15th October 2020

I am writing concerning the possible Nursery Fields Development off of Chalcraft Lane, North Bersted. Whilst I appreciate that the site is now included as part of the West Bersted Strategic Site, I would like to make a few comments at this stage, before it goes for outline planning consent, which may influence your comments to Arun District Council's Planners.

Site Location Plan - 02

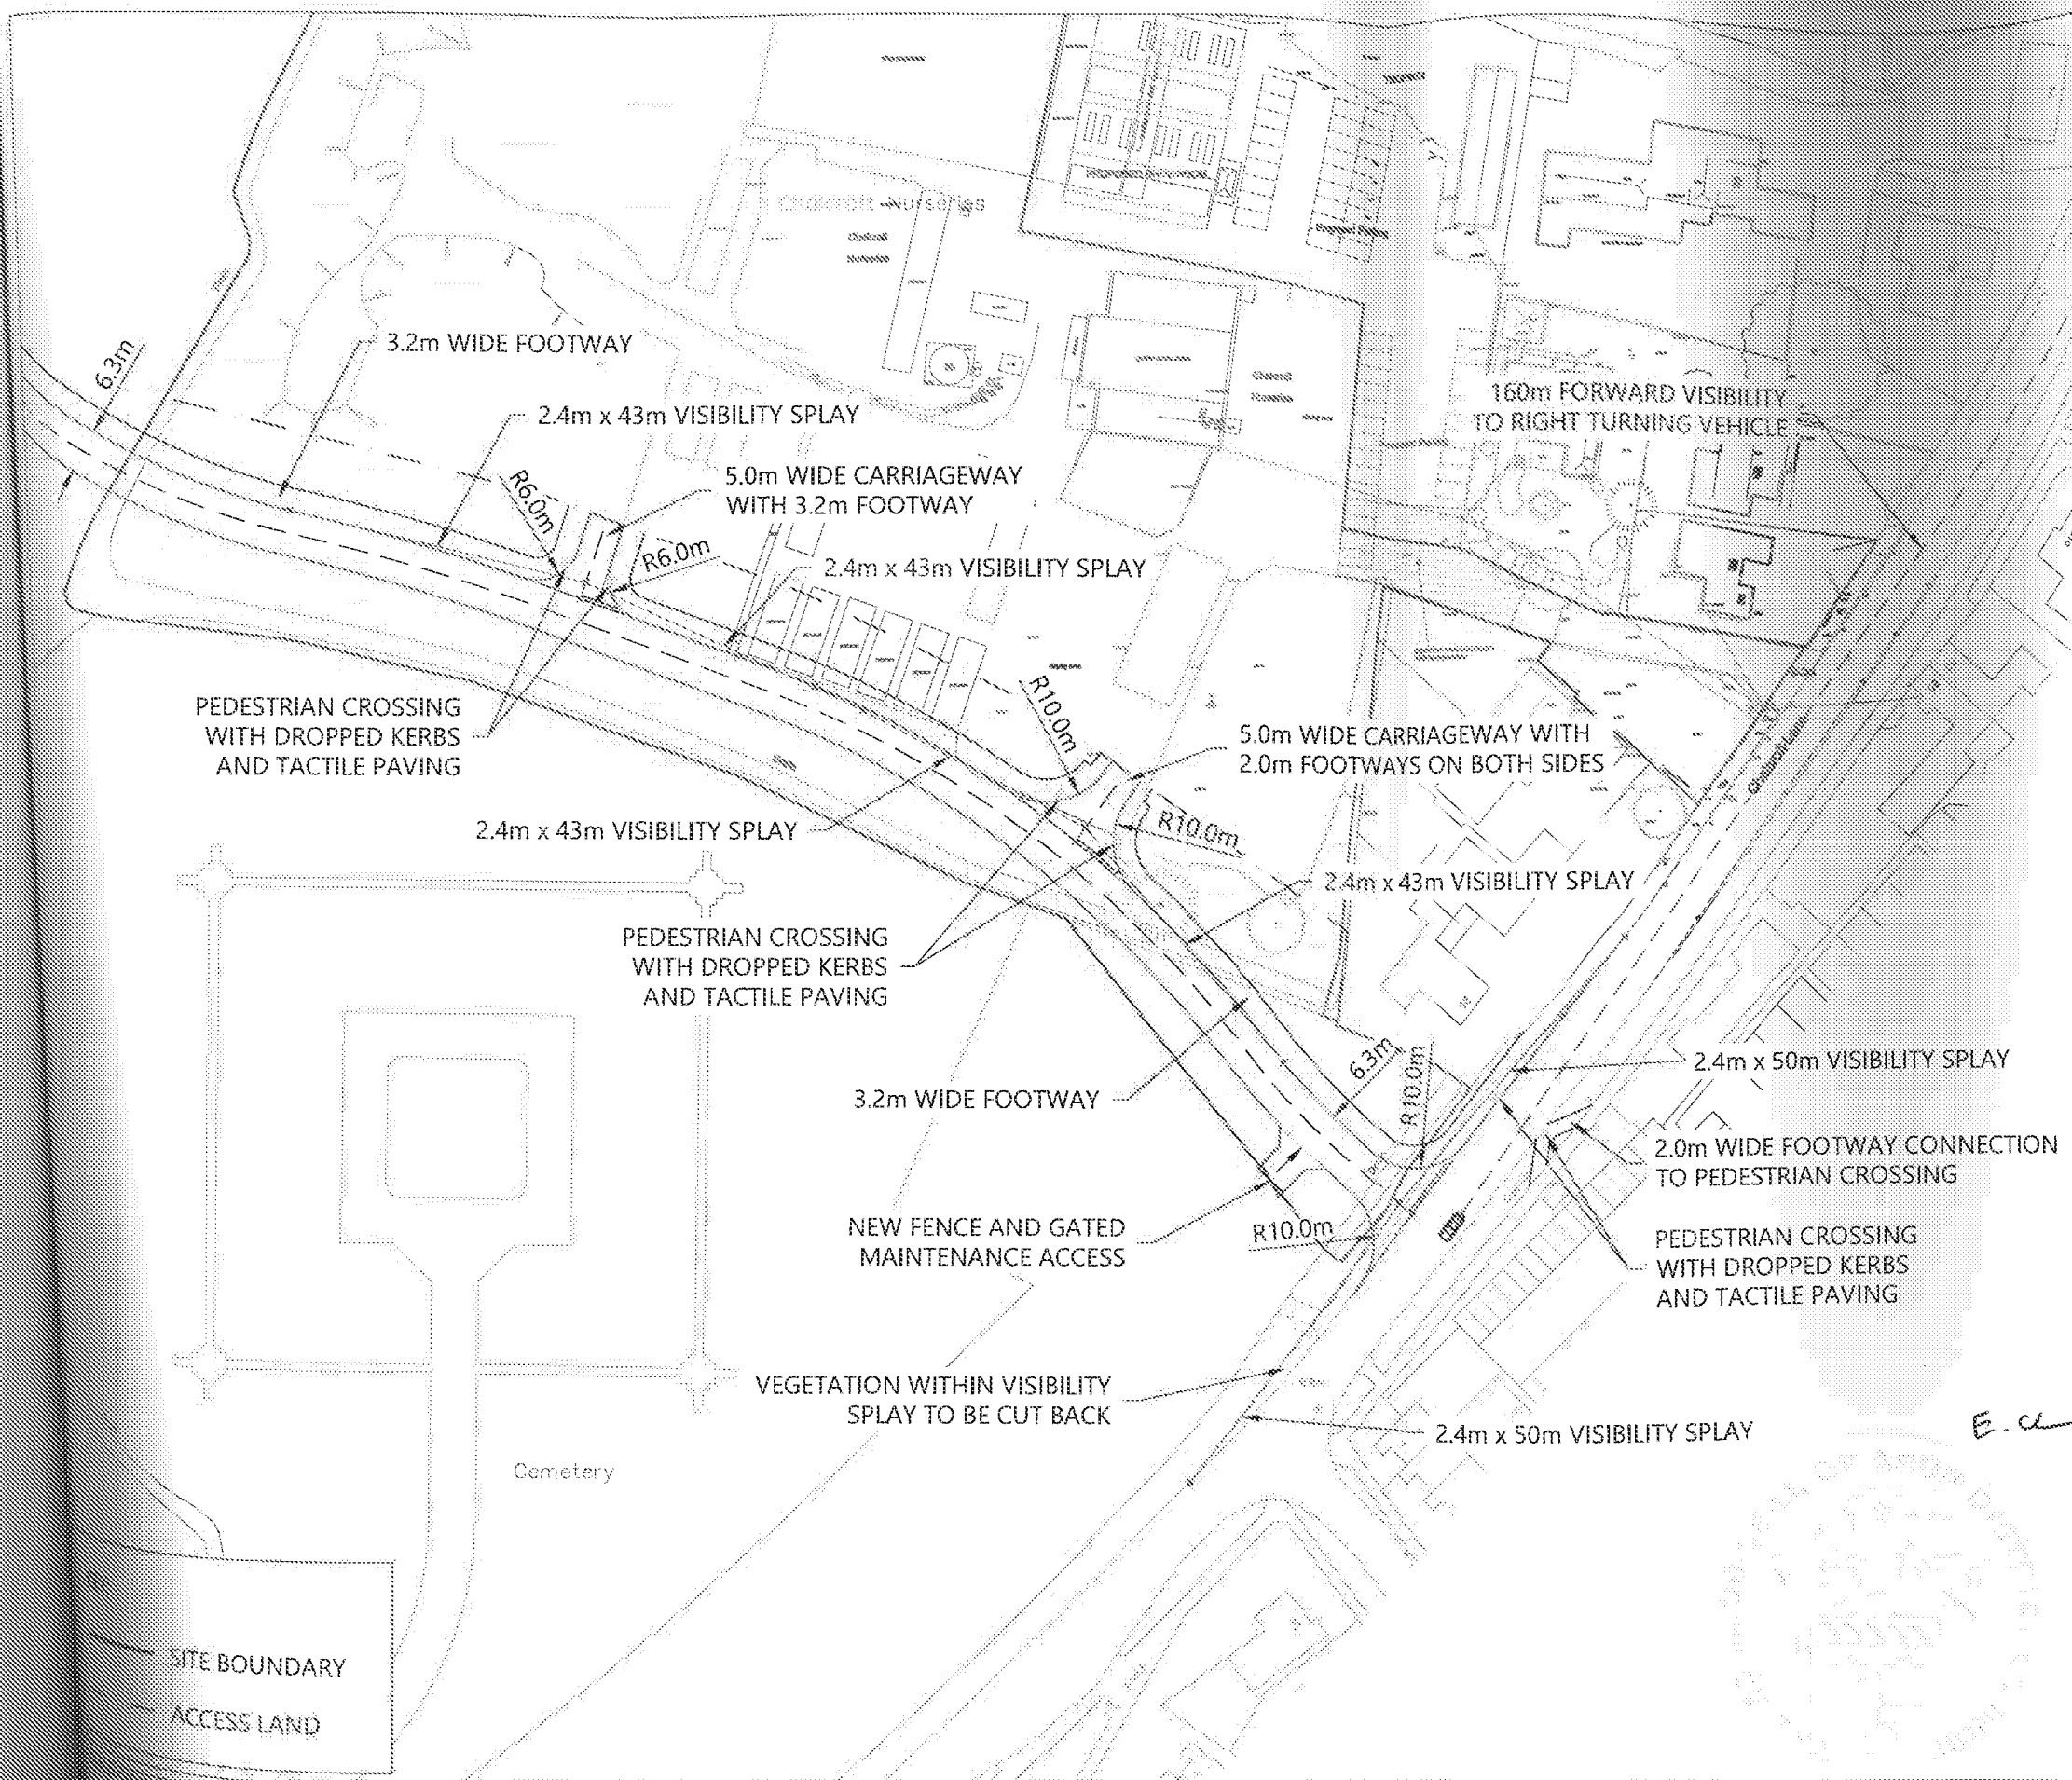
I note Stephen Greer's comments on BE/81/20/OUT (the Chalcraft Nursery site) and would agree that the proposed access is inadequate if that entrance is to be used to access the Nursery Fields development. Whilst in theory a ghost island would suffice. I don't think it can be constructed within the existing highway. There is a bungalow to the west and south of the site, which already has a steep access, something I pointed out to Arun when they granted permission. In order to widen the road this slope would be significantly increased. The properties on the northside preclude any widening on that side of the road and unless a dog-leg in the main alignment is introduced, which is not desirable, then I feel that a satisfactory solution cannot be achieved. I am also concerned about the highway drainage. A stream runs alongside the highway and is then culverted under the road. The proposed bellmouth is directly over this which would make maintenance nigh on impossible.

Since completion of the Bognor Bypass, traffic on Chalcraft Lane has increased significantly as vehicles heading from East to West now use this route rather than the old Felpham > Seafront > Aldwick/Pagham route. This volume of traffic can only increase with the proposed Pagham developments. Already, at peak times traffic backs up down West Meads Drive and I feel that the best solution would be the construction of a roundabout at the junction of West Meads Drive and Chalcraft Lane, with the existing entrance to the cemetery altered and a road constructed around the edge of the cemetery to serve this development. This would obviate the need for the ghost island and would resolve the traffic problems. I would also suggest that it may be cheaper for the developer given the location of the underground services.
